Our Reference: SYD17/00465/05 (A22050565)
Department Ref: SSD 8372

**PROPOSED DEMOLITION AND CONSTRUCTION OF SMALLS ROAD PUBLIC SCHOOL –
RESPONSE TO SUBMISSIONS
3B SMALLS ROAD, RYDE**

Reference is made to the Department's letter dated 10 April 2018, regarding the abovementioned Application which was referred to Roads and Maritime Services (Roads and Maritime) for comment in accordance with the *State Environmental Planning Policy (Infrastructure) 2007*.

**Site: 5 [Blaxland Road x North Road AM 2017]**

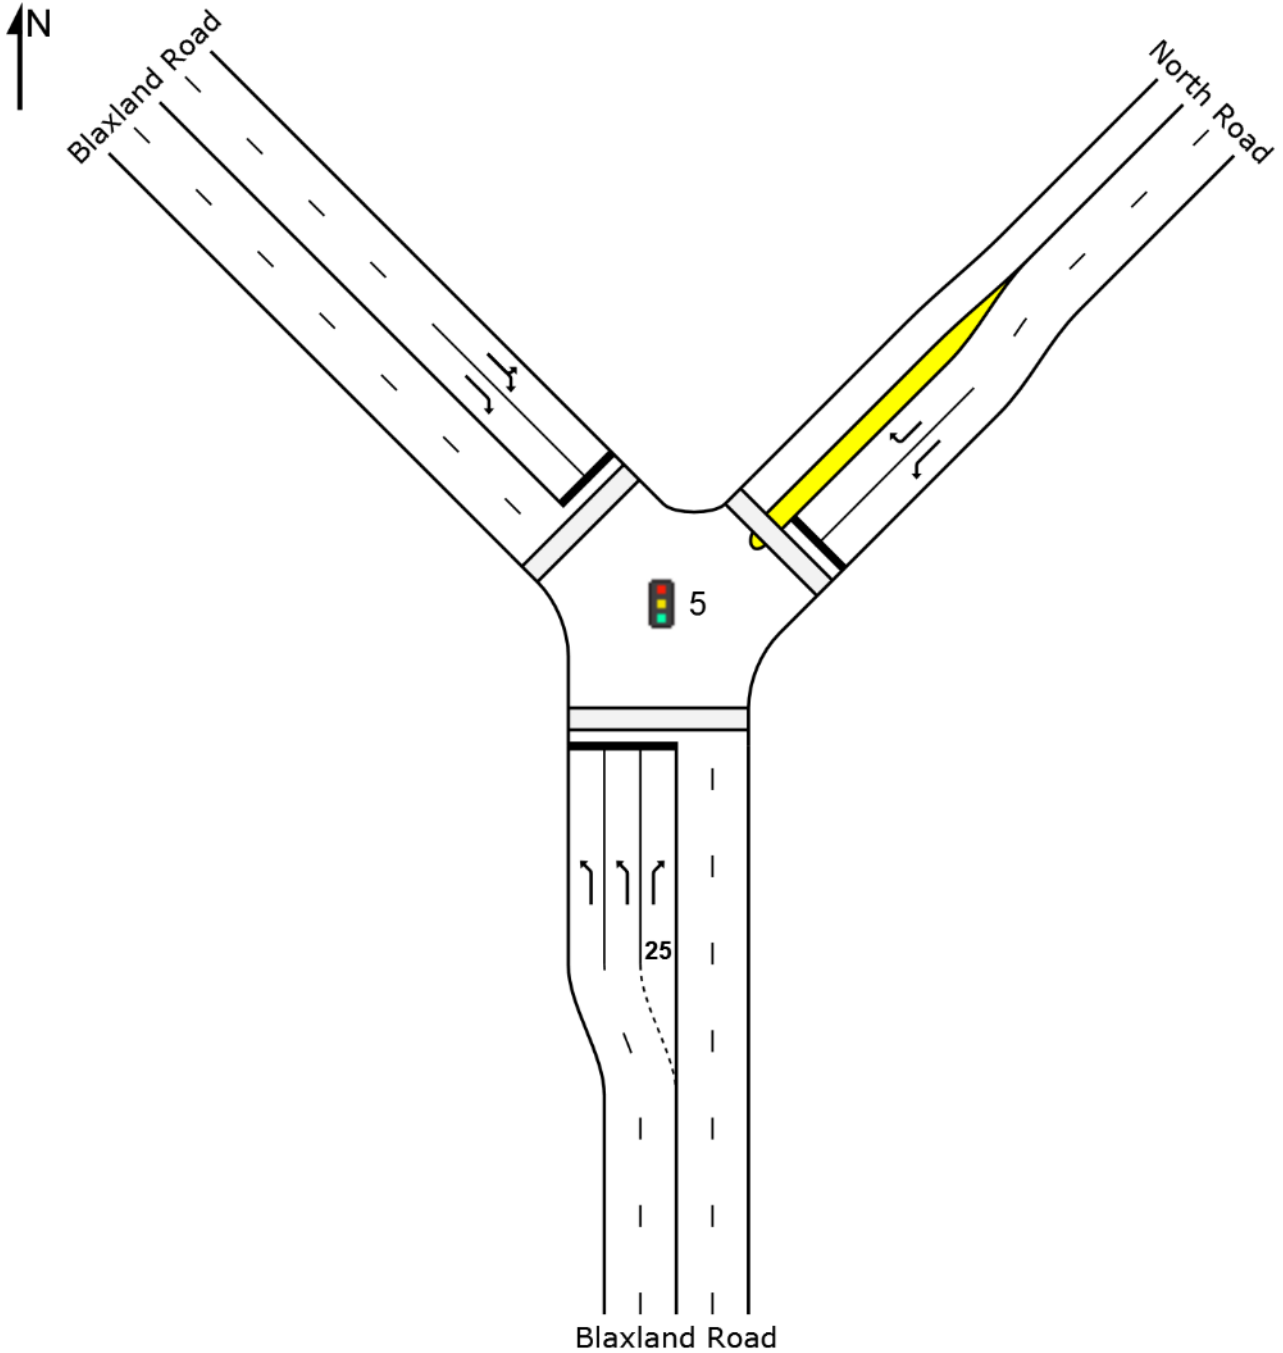
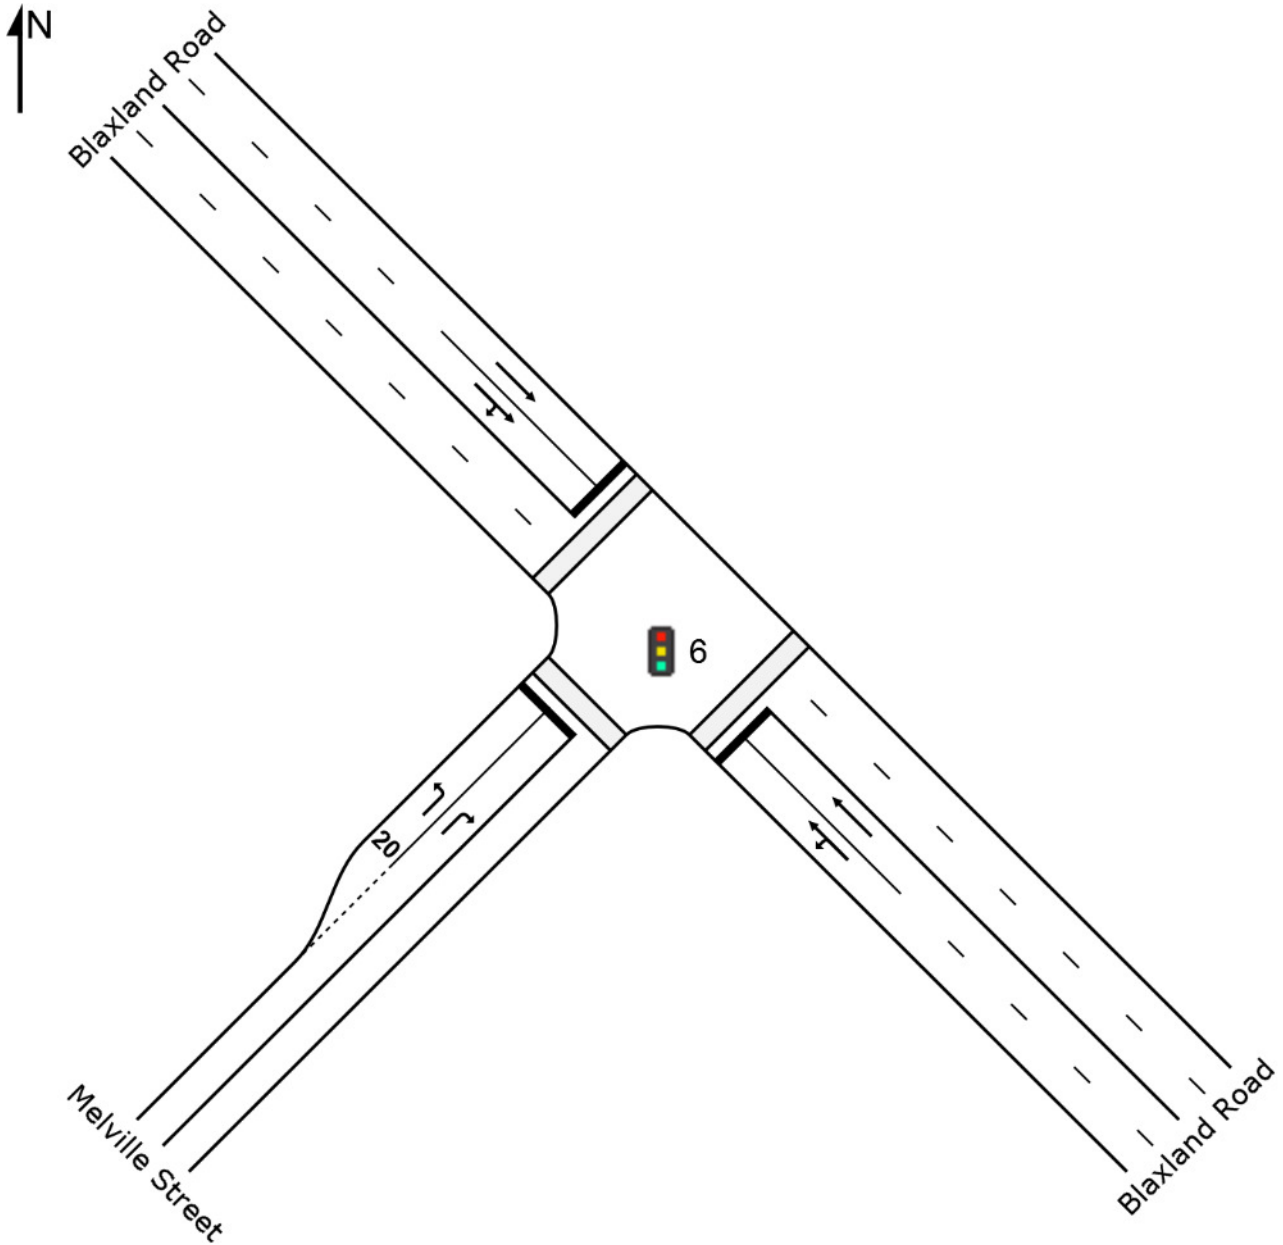
- Intersections of Blaxland Road and Melville Street and Blaxland Road and North Road operate as a single intersection and share the cycle time. This needs to be reflected in the traffic modelling.

- The maximum cycle time for Blaxland Road/Melville Street/North Road intersection is 120 seconds, not 100 seconds as shown in the model.
 - According to the traffic modelling for Blaxland Road and North Road intersection for the PM peak in 2027, the right turn from Blaxland Road southern approach into North Road is predicted to queue out (28.6 m queue length opposing existing 25 m long right turn bay). This would indicate that the right turn bay need to be extended.
